30 April 2026

Regarding: Formal Objection to SSD-83867719 – 45-53 Macleay Street, Potts Point (The Chimes)

Figure 5 Section A – Height Exceedance of Proposed Development

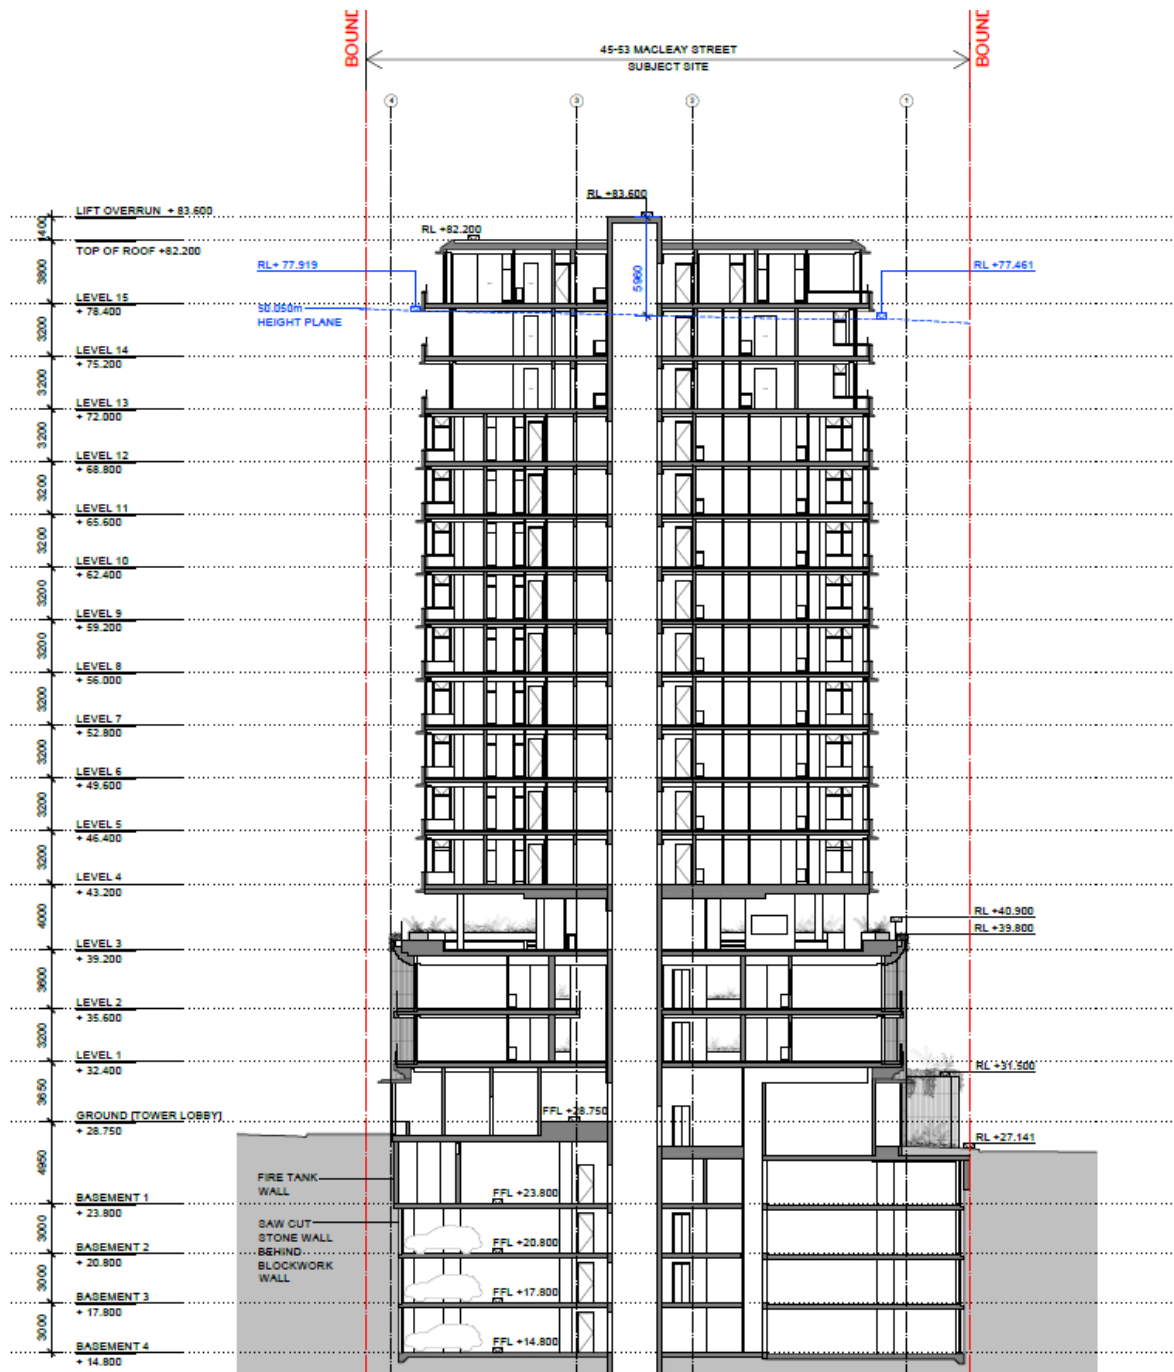
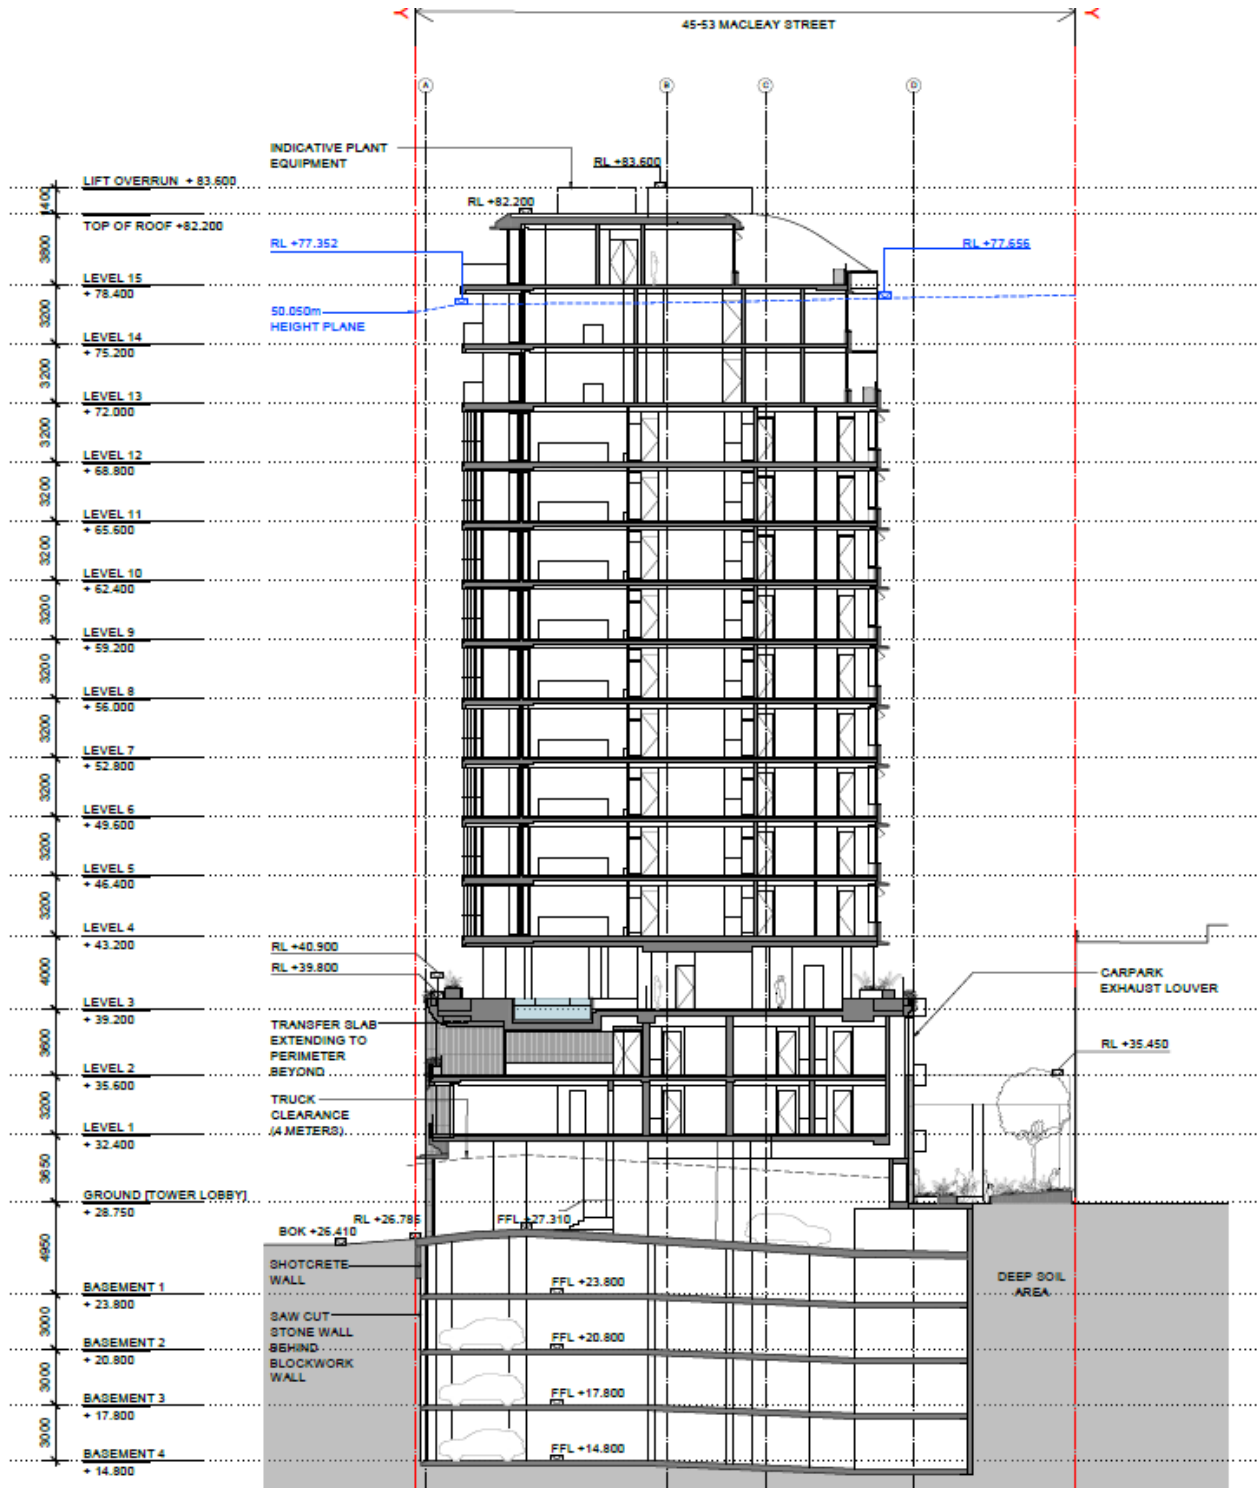
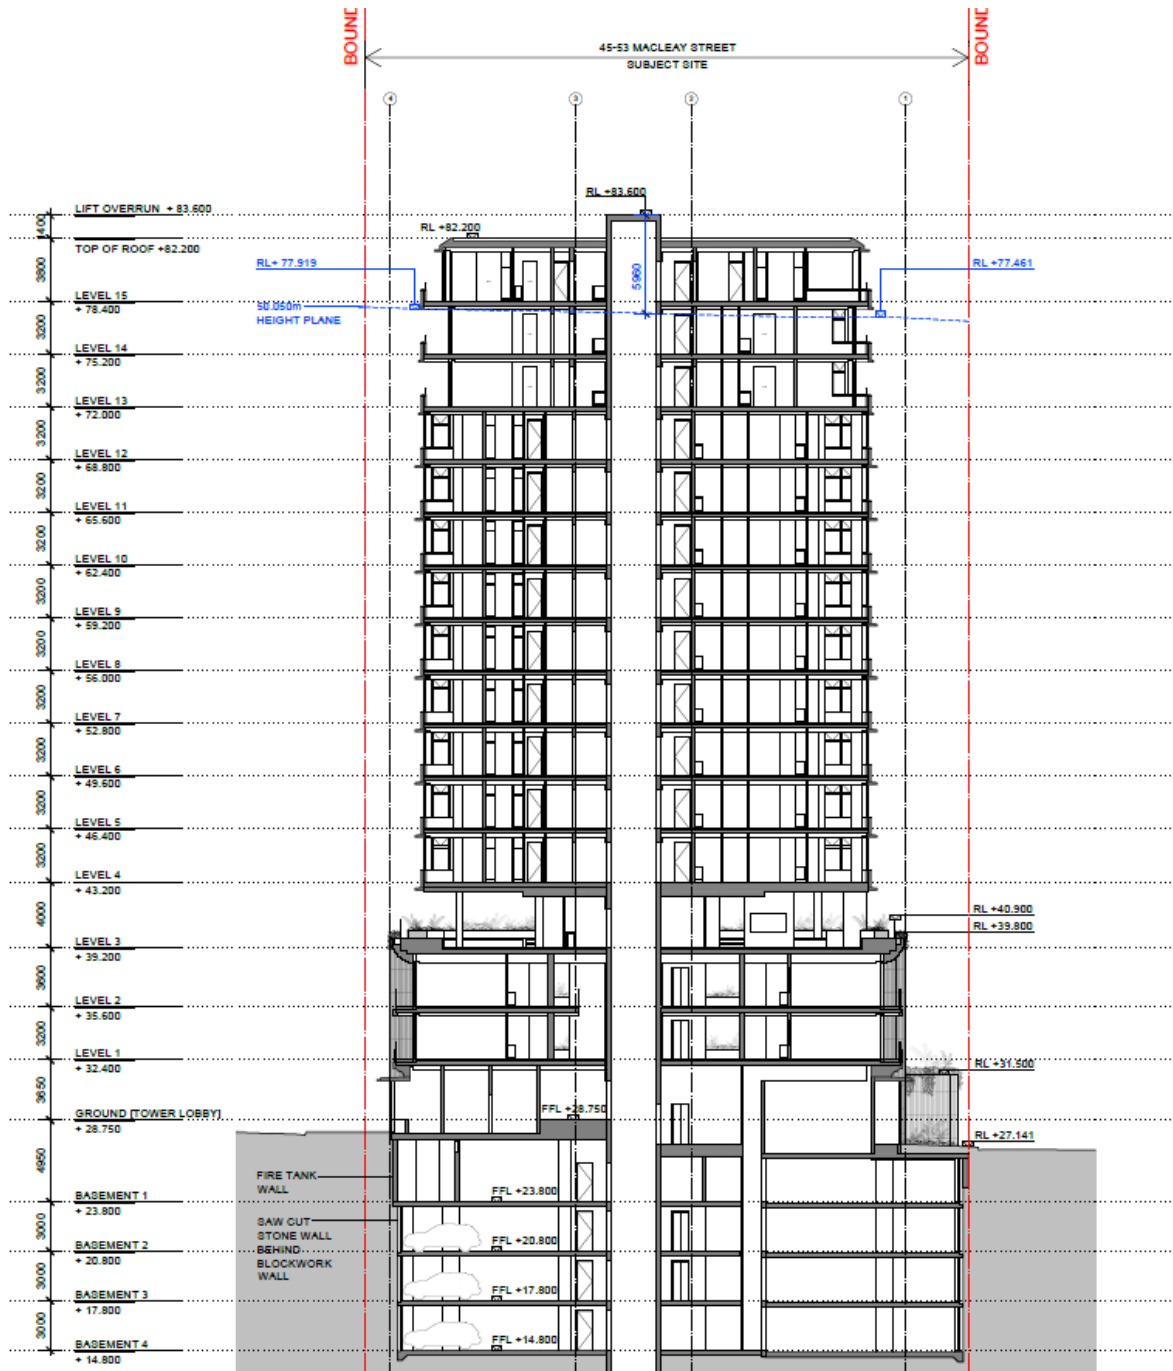
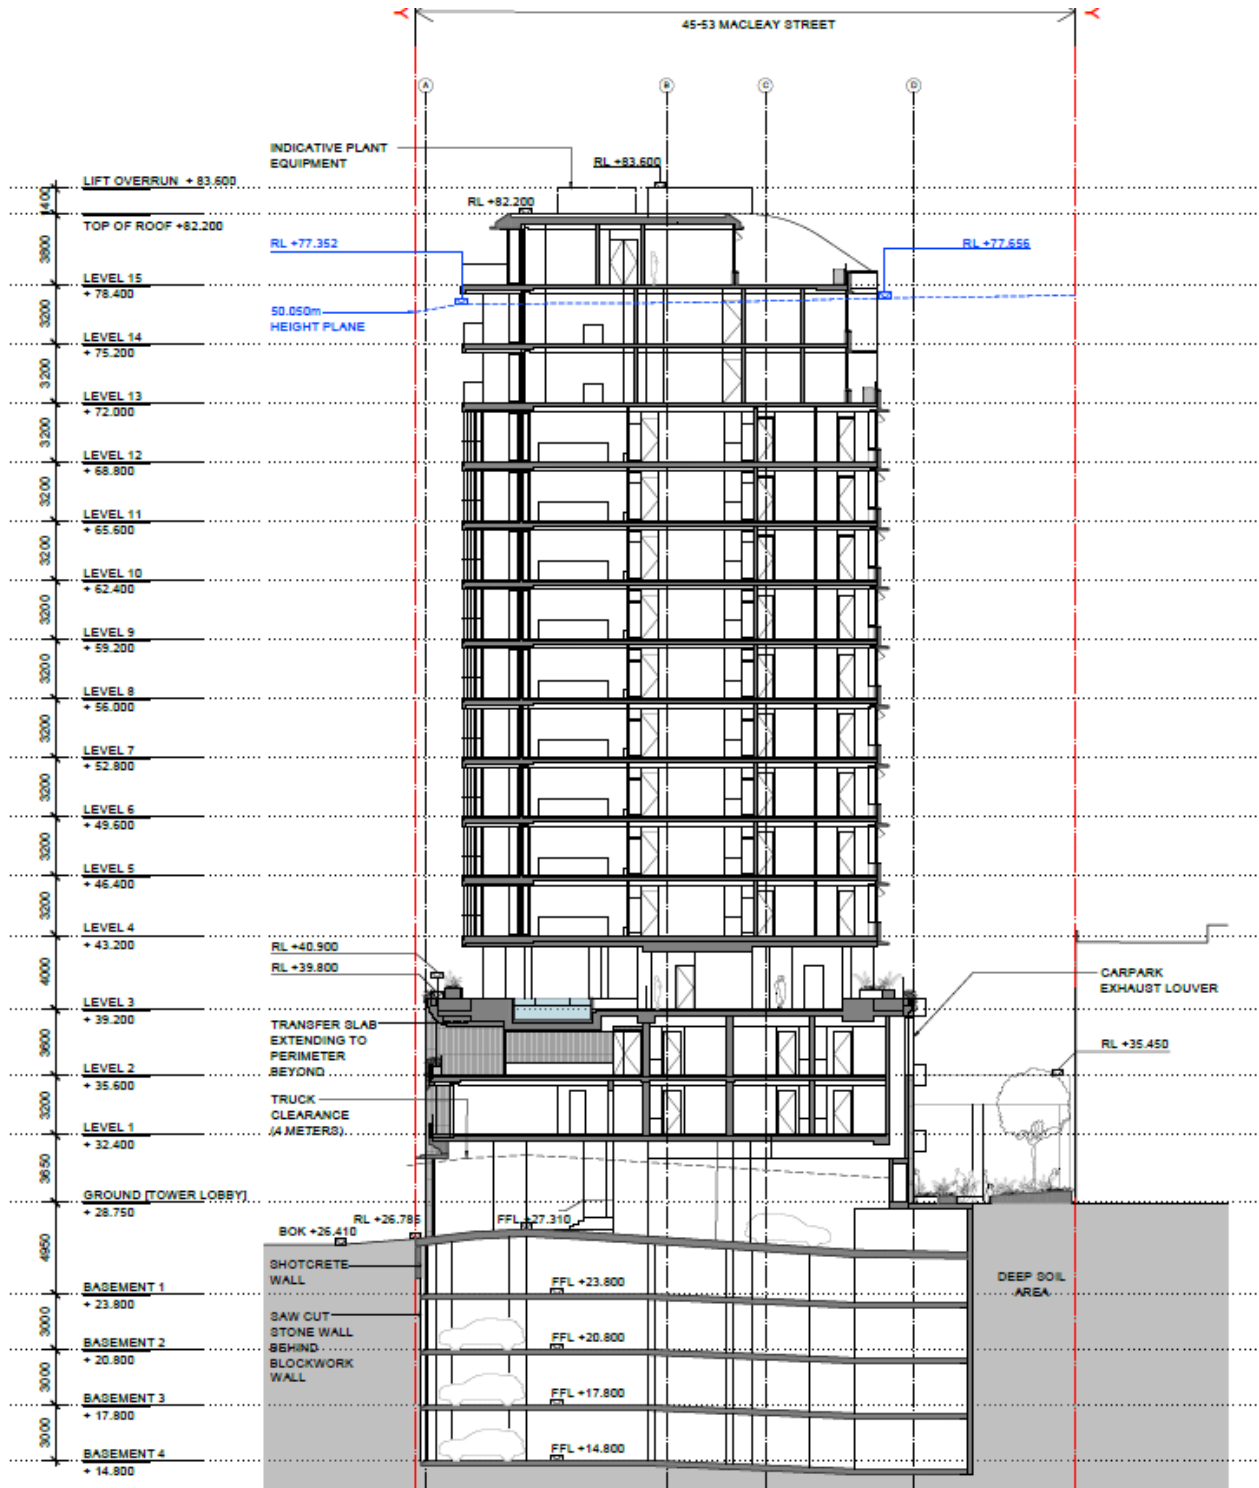
The proposal seeks a maximum building height of **56.01m (RL 83.6)**, representing a **5.96m (11.9%) exceedance** over the maximum permissible height of 50.05m—a limit that already includes a 30% affordable housing bonus and a 10% design excellence bonus 1.

Under the legal test established in *Initial Action Pty Ltd v Woollahra Municipal Council*, the applicant must demonstrate that compliance is "unreasonable or unnecessary" 2. The developer's justification in **Appendix K** is technically flawed and factually contradictory. While the **Clause 4.6 Variation Request (Prepared by Urbis)** labels the exceedance as being for "essential building elements" and "plant," the detailed sections reveal that the over-height zone specifically contains "**part of the Level 14 sub-penthouse**" and the "**Level 15 penthouse apartment**" 3, 4.

It is legally indefensible to argue that the provision of **luxury habitable penthouse space** constitutes a "sound environmental planning ground" for a significant height breach. The public benefit of affordable housing (relegated to the lower podium) does not necessitate a height variation for a private luxury residence on Level 15 2, 5.
